Demolition of existing ground floor extensions to front of property, construction of a single storey rear extension & reworking of existing external hard & soft landscaping. This application affects the character & appearance of the Craigweil House Conservation Area.

36 Kingsway Aldwick

OBJECTION to AW/79/18/HH

Drawing
Arboricultural Impact Assessment,
Arboricultural Method Statement

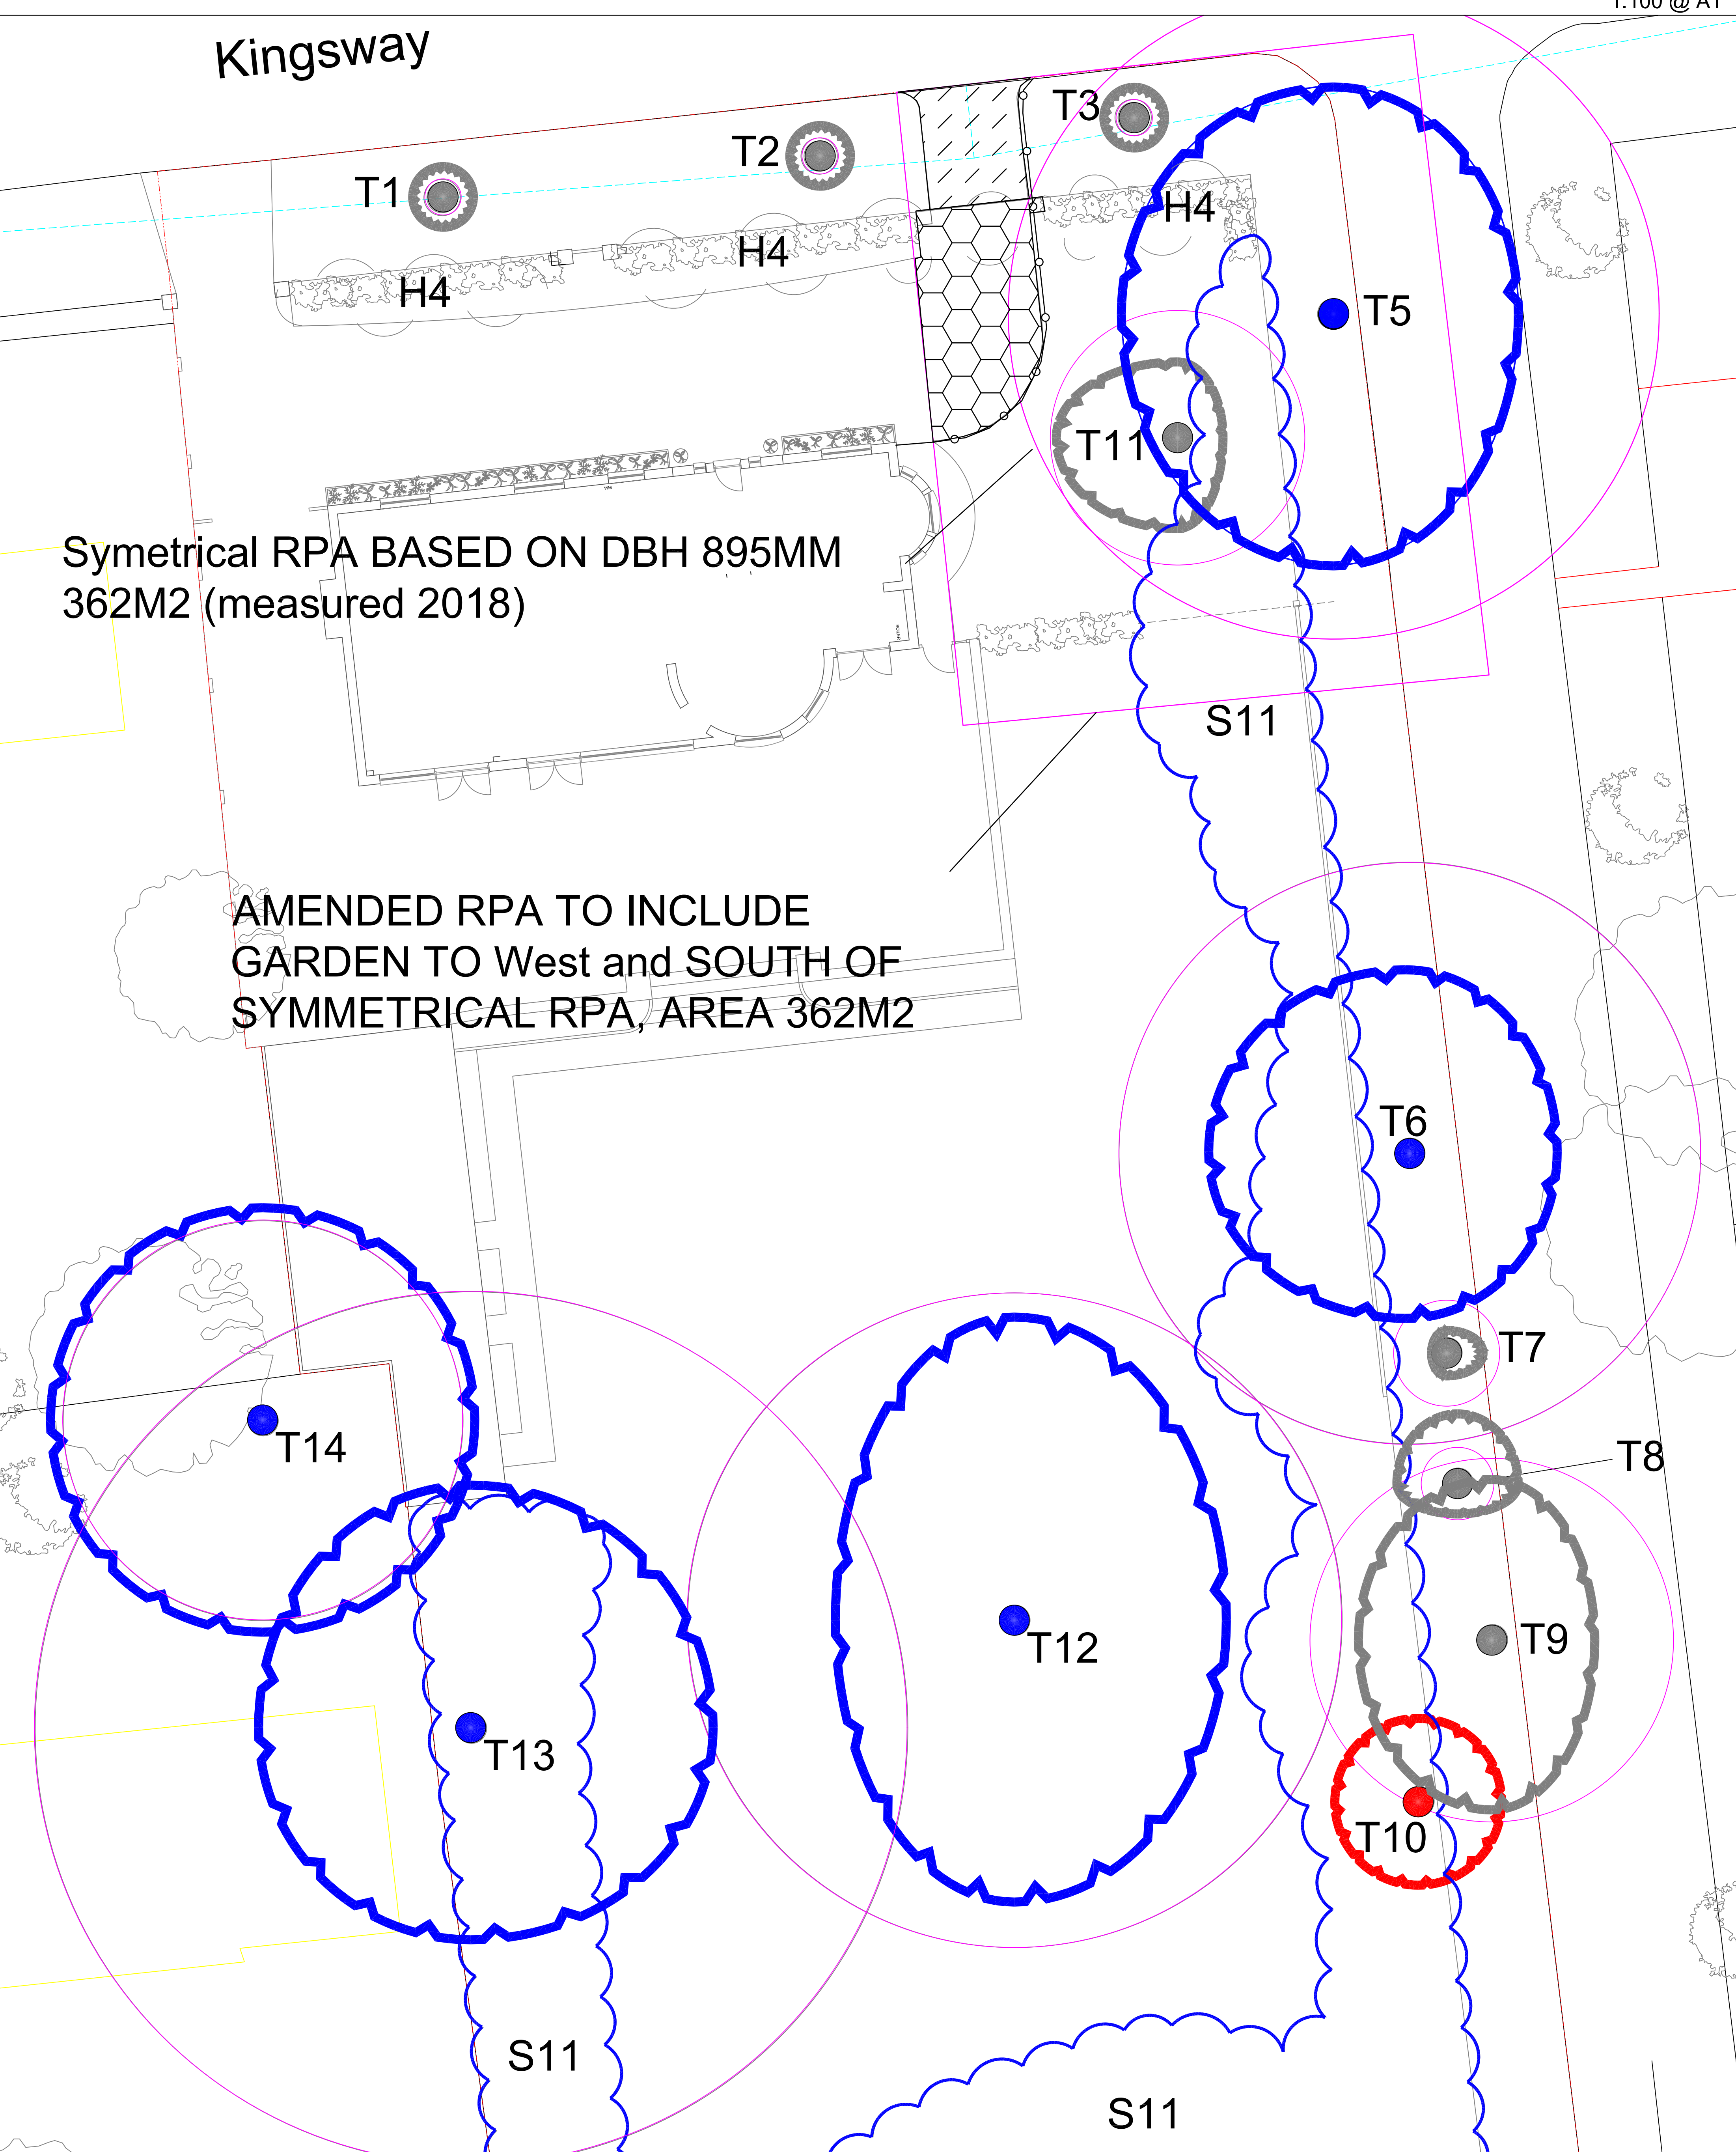
I am also concerned that the TPO'd tree on the verge at the junction with Kingsway and Queensway will be severely at risk from the proposed development. I do not believe it is placed in the correct position on the plans. The Arun Arboriculturist MUST view this/these trees and pass opinion upon the risks there are to them.
